From: Sue Howell
Sent: 06 July 2015 16:28
To: Planning.Responses
Cc: Juan Baeza
Subject: RE: Planning Consultation on LU/197/15/DOC

APPLICATION LU/197/15/DOC
NO:

Registered: 12-JUN-15
Site Address: Land at Brook Barn Farm Courtwick Lane

Application for approval of matters reserved by conditions imposed under LU/385/14/PL relating to condition No's 3, 8, 10, 11 & 12 - Solar Farm Materials, Landscaping Scheme, Traffic Management plan & SHE Quality plan.

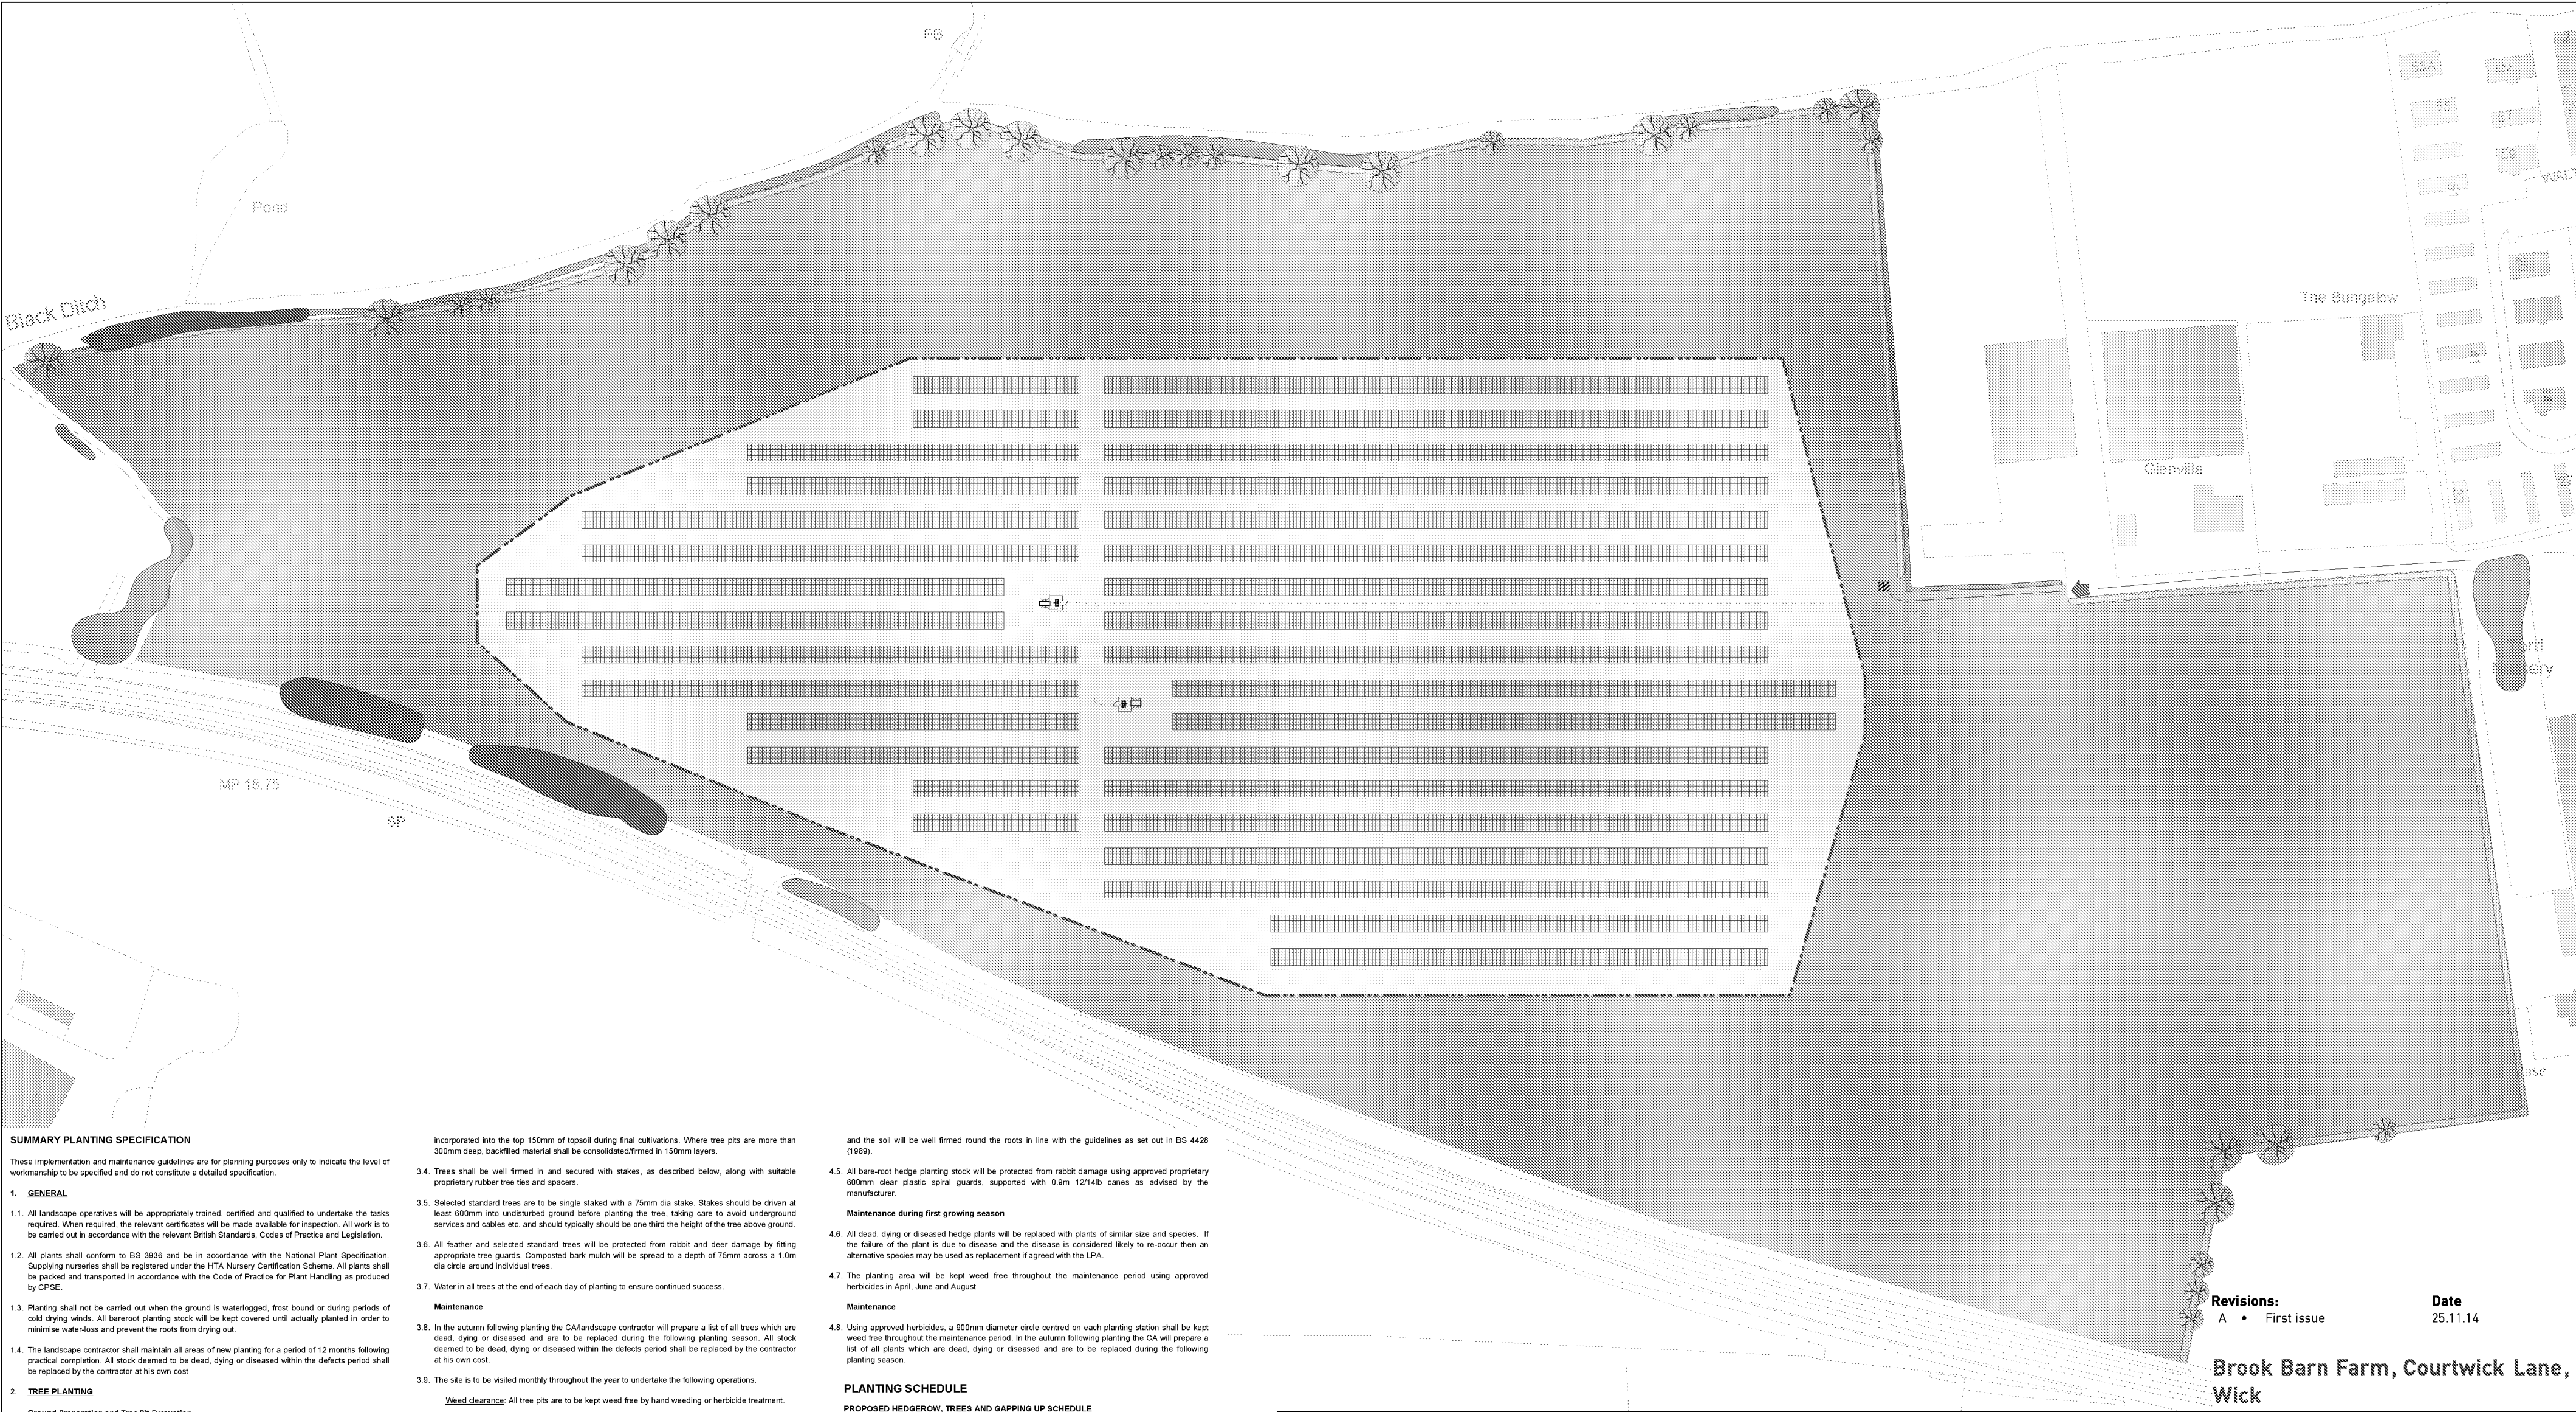
The landscape plan BNL.0638-06-A Revision A submitted under application LU/197/15/DOC does not adequately detail proposed planting. The detail needs to be in plan form and needs to show actual quantities and locations for proposed planting. Indicative areas of proposed planting is not sufficient to adequately show where planting is to be located. The drawing schedule presently indicates proposed sizes only, this needs to be incorporated into a schedule with the quantities so that a clear picture of the proposals can be seen.

We would require that the above information is submitted and agreed and therefore **we would not at this stage recommend the discharge of Condition 8 on this application**
